Subject: FW: Kariong Sand and Soil Supplies Facility (SSD-8660) – Submissions Report
Attachments: signature_Roger.png

Subject: RE: Kariong Sand and Soil Supplies Facility (SSD-8660) – Submissions Report

I have reviewed a few items for this project and note the following :

PROJECT: PROPOSED KARIONG SAND & SOIL SUPPLIES FACILITY - SSD8660
GENERAL ARRANGEMENT PLAN

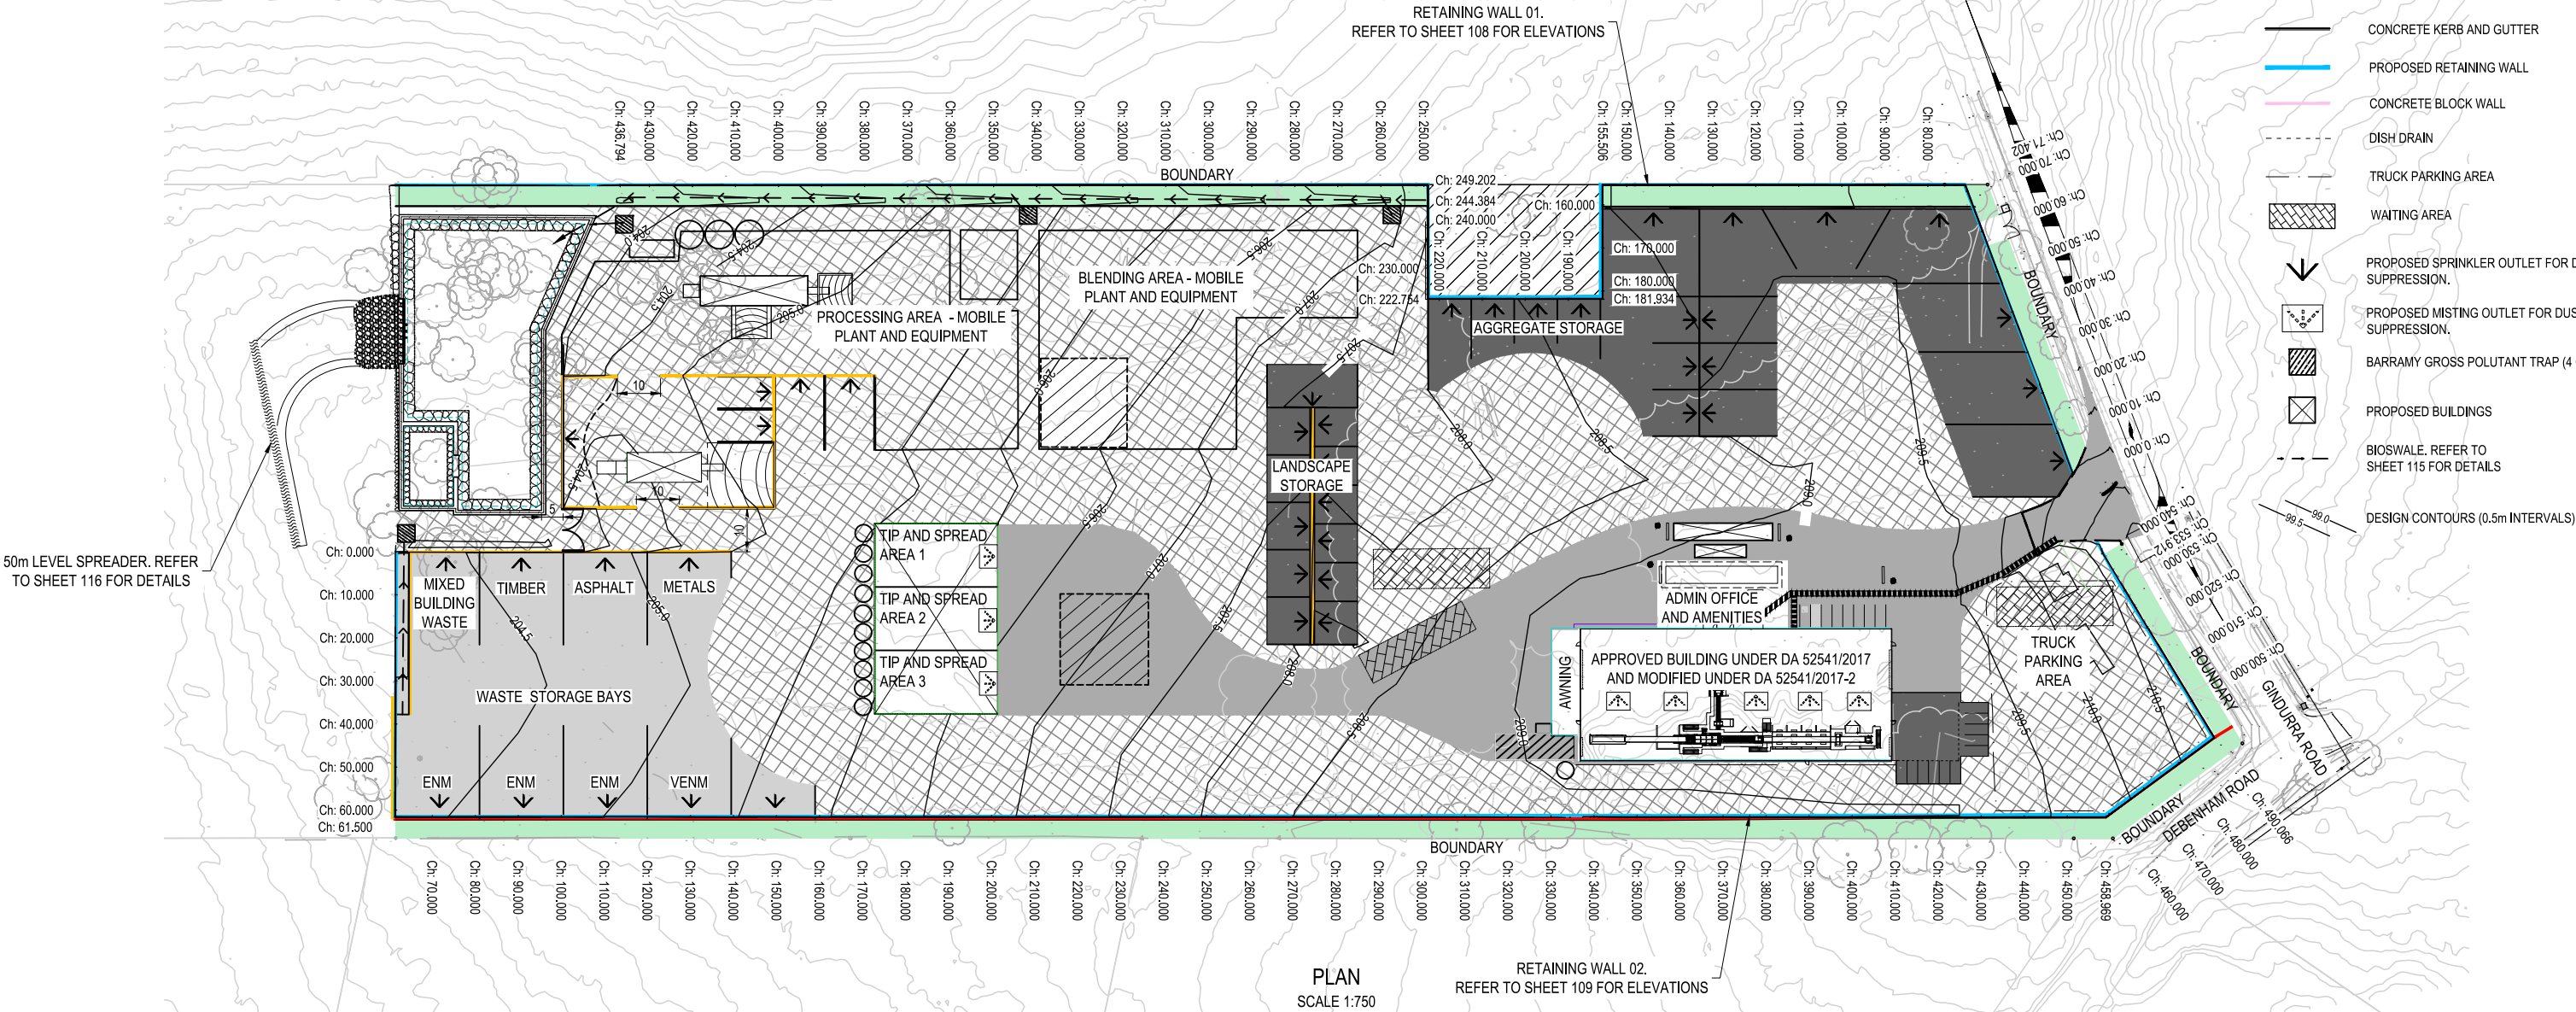
- The updated enclosed crusher is a positive and will provide more attenuation for sources located within this space. The gap will detrimentally affect the attenuation performance of the shed though.
